July 11, 2019

Re: Project #PR-2019-002496 for Southeast Corner of Alameda Blvd. NE & Barstow Street NE

It has been brought to the attention of our Vineyard Estates Neighborhood Association that an application by Consensus Planning for a site plan on behalf of Philip Lindborg for development of 93 apartments on the southeast corner of Barstow Street NE and Alameda Blvd. NE is set for a Development Review Board hearing on July 17, 2019. It is our understanding that the property zoning is MX-L under the current IDO and this application is a permissive use of the property.

① Phase A-South
1/8" = 1'-0"

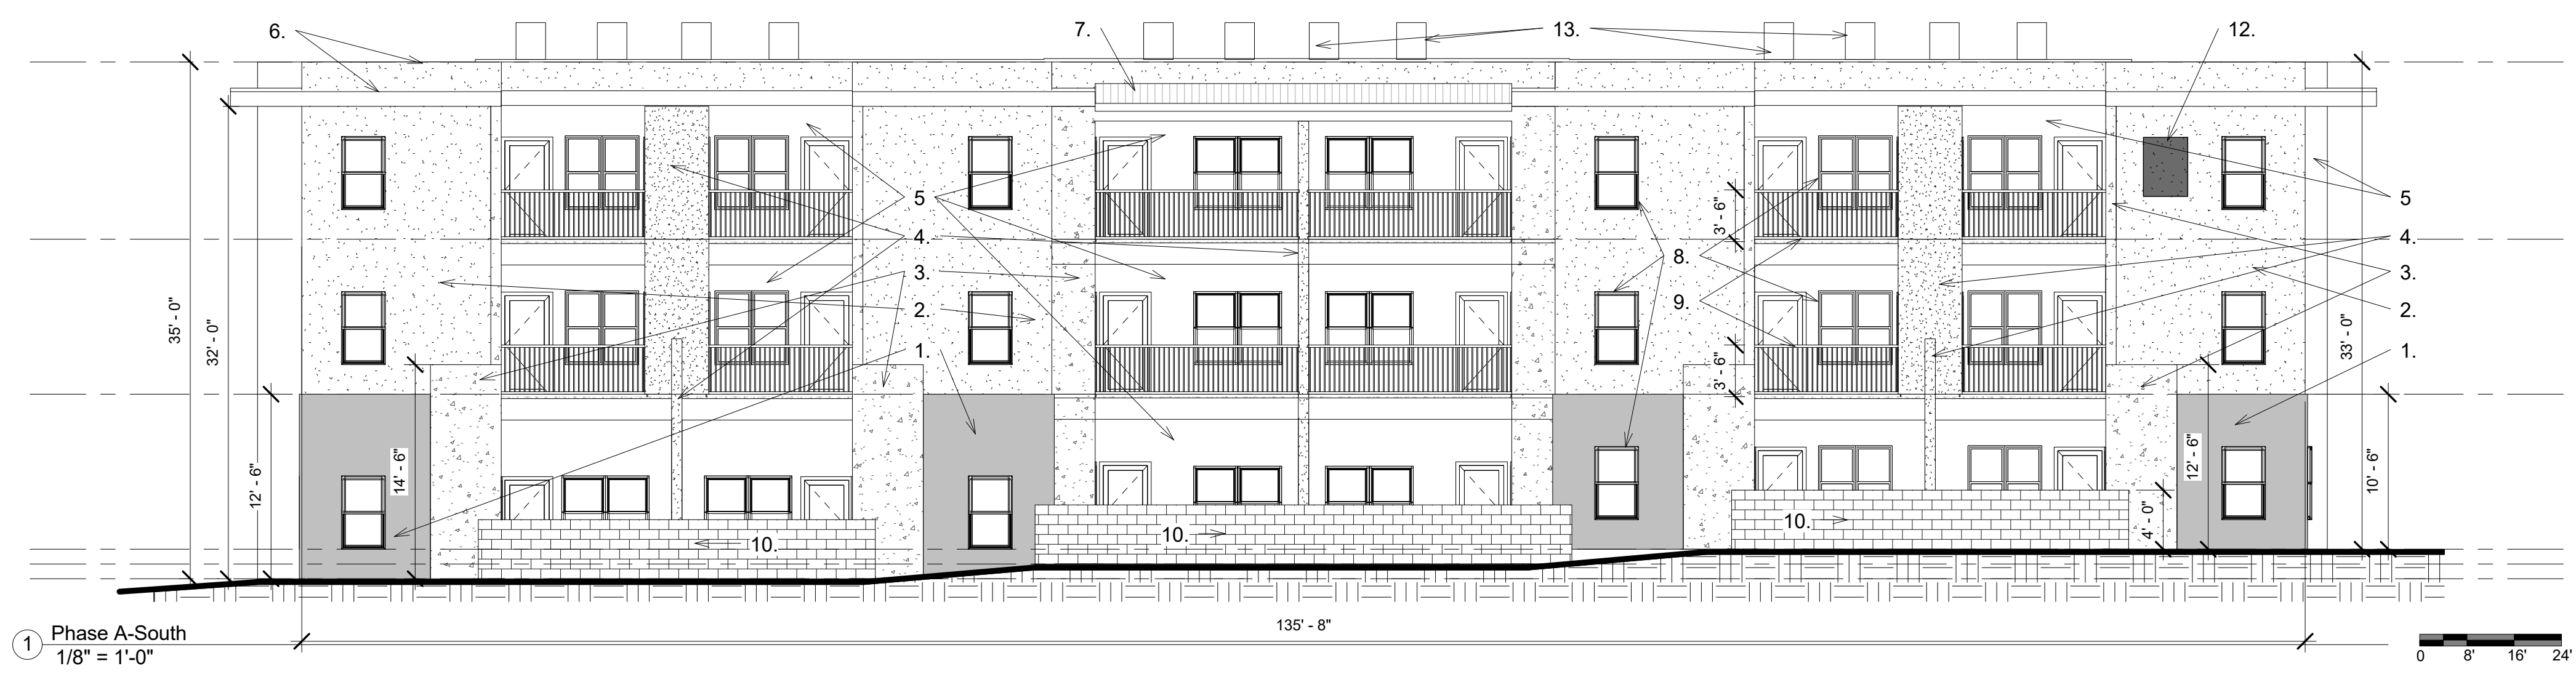
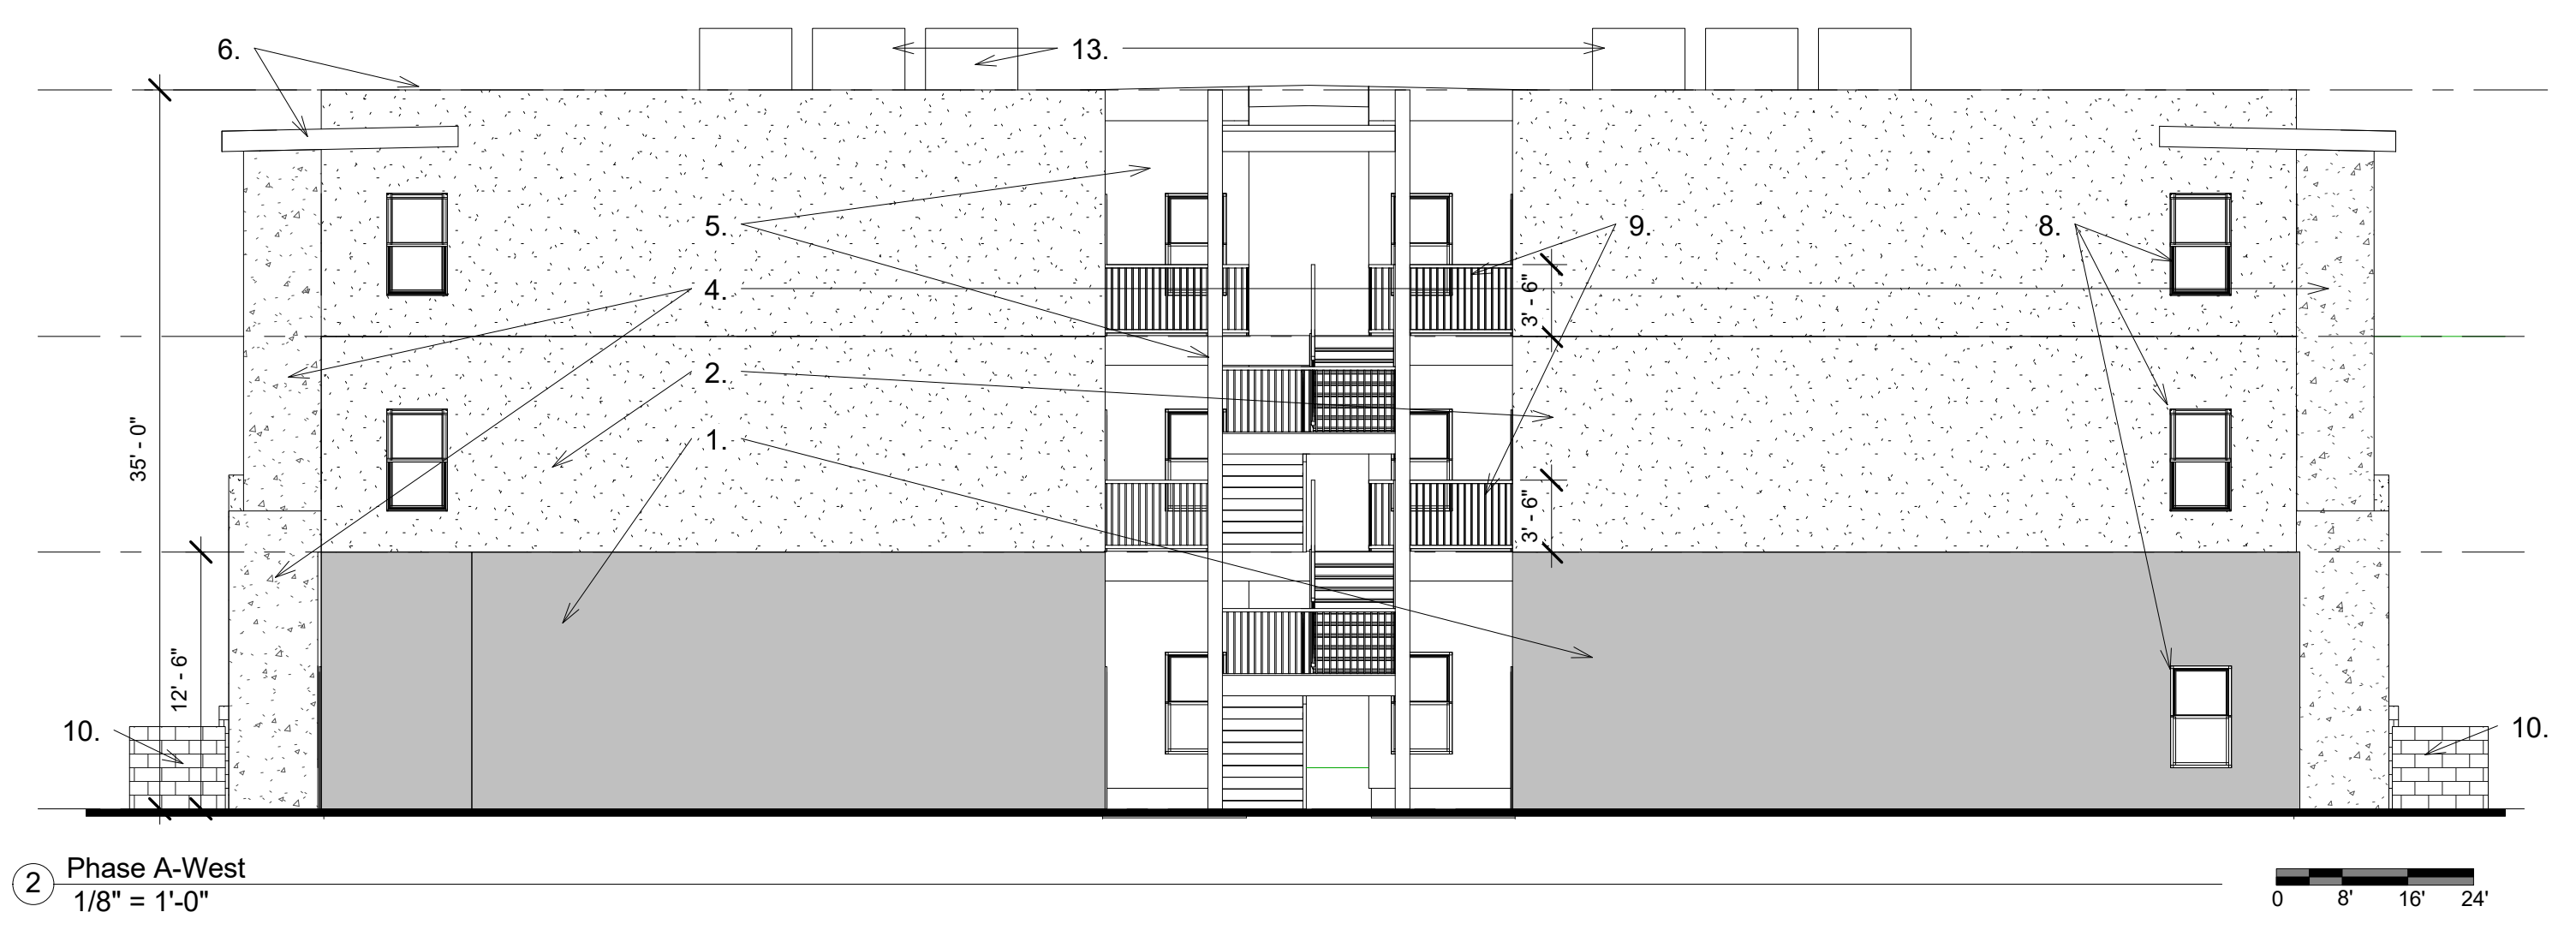
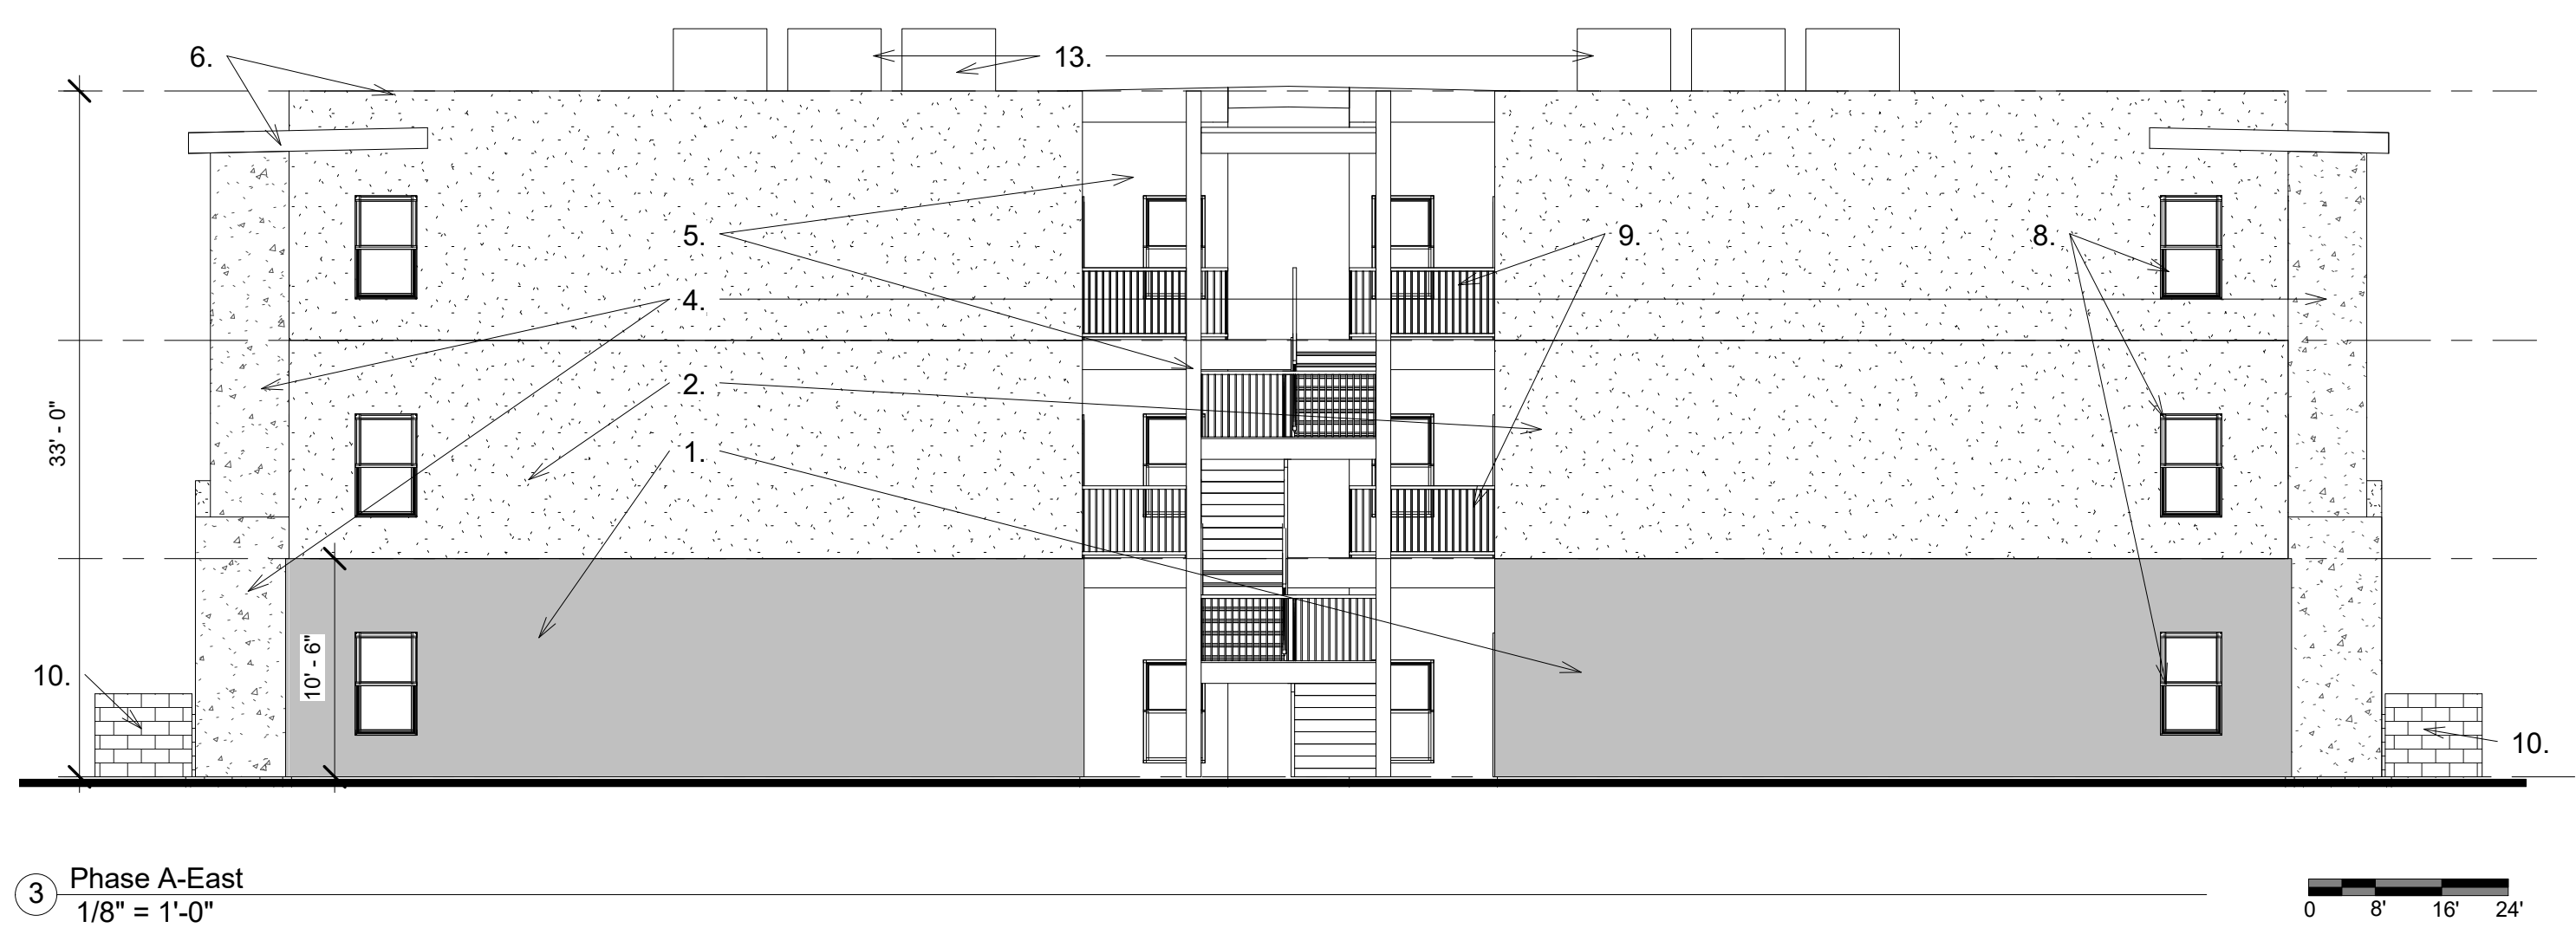
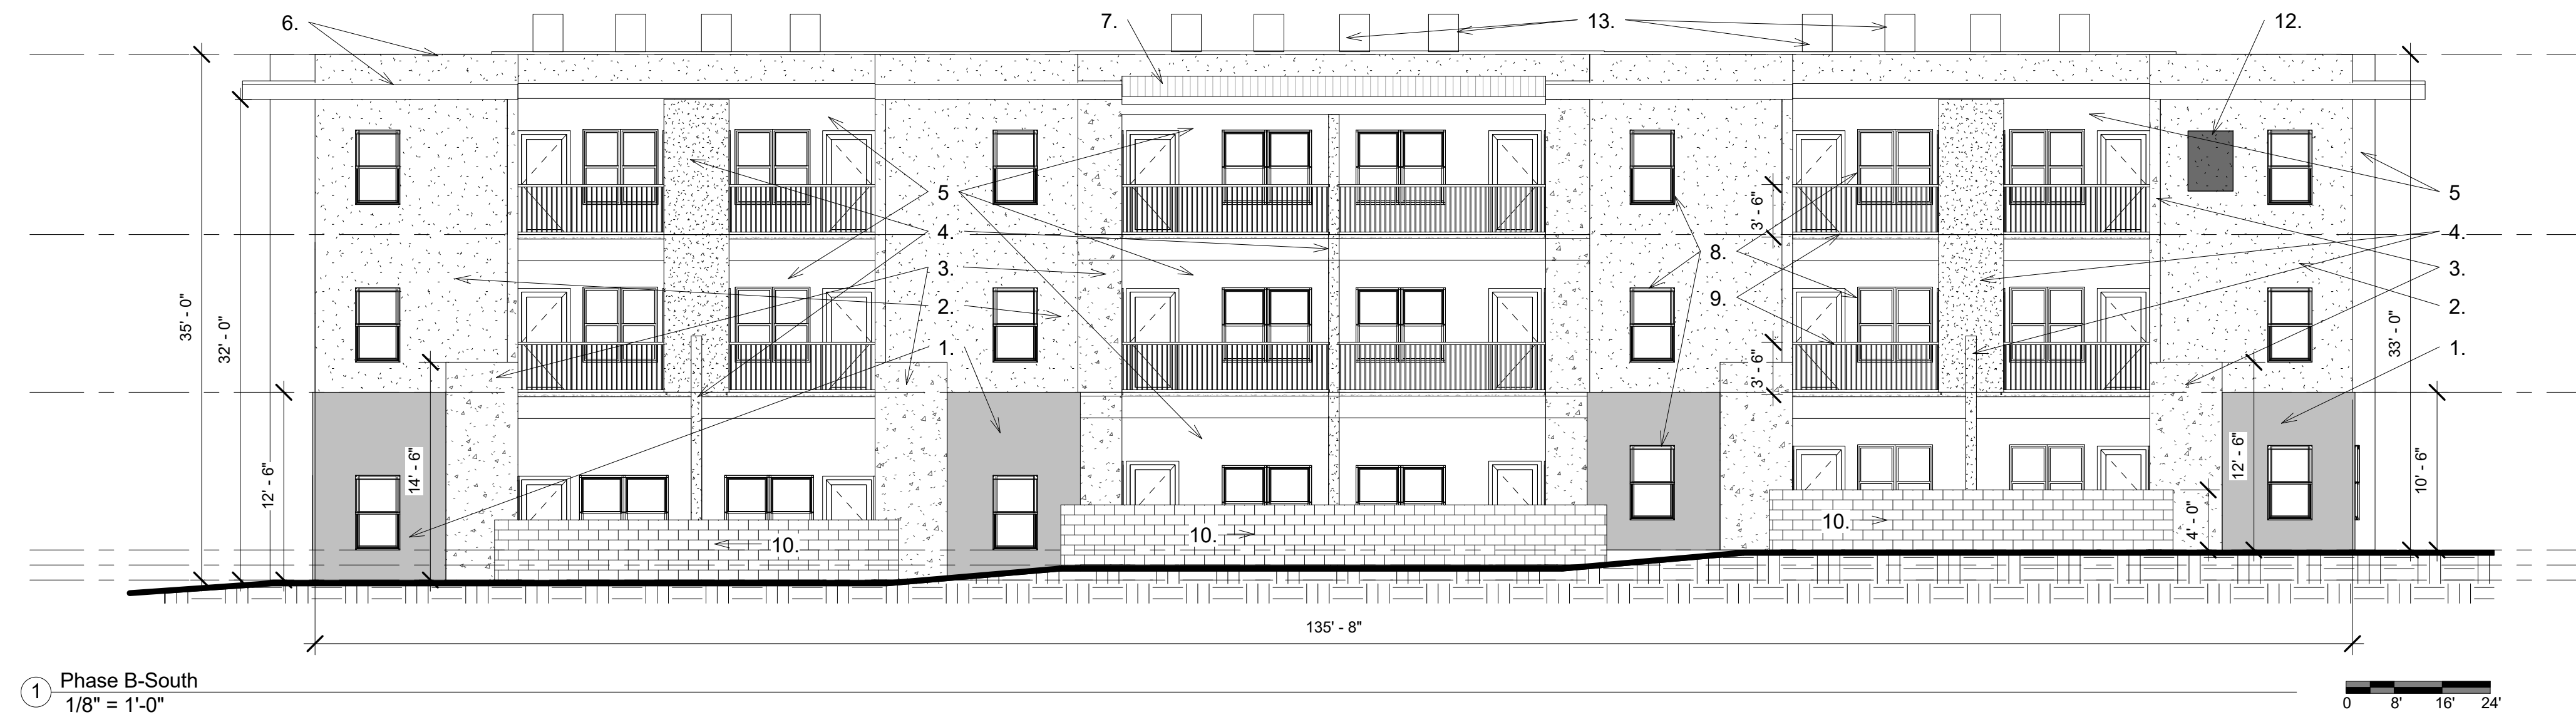
- 4) **Urban Design Style:** The design style of a 3-story, flat roof, brightly colored building (red, brown, orange, green per color-rendering Jeebs & Zuzu, Inc. provided documents) does not blend in with the surrounding earth tone homes (many of which have covenants clarifying appropriate paint color choices of which these colors would not be allowed) and gabled roofs of Tierra Morena (south-affected neighborhood), Pico la Cueva Place (north-affected neighborhood), and Tierra Montana Place NE (west-affected neighborhood). Use of black chain-link fencing as the security surround also does not fit with the tasteful design required by the surrounding neighborhoods’ covenants of stuccoed walls or wrought-iron gates/fencing to
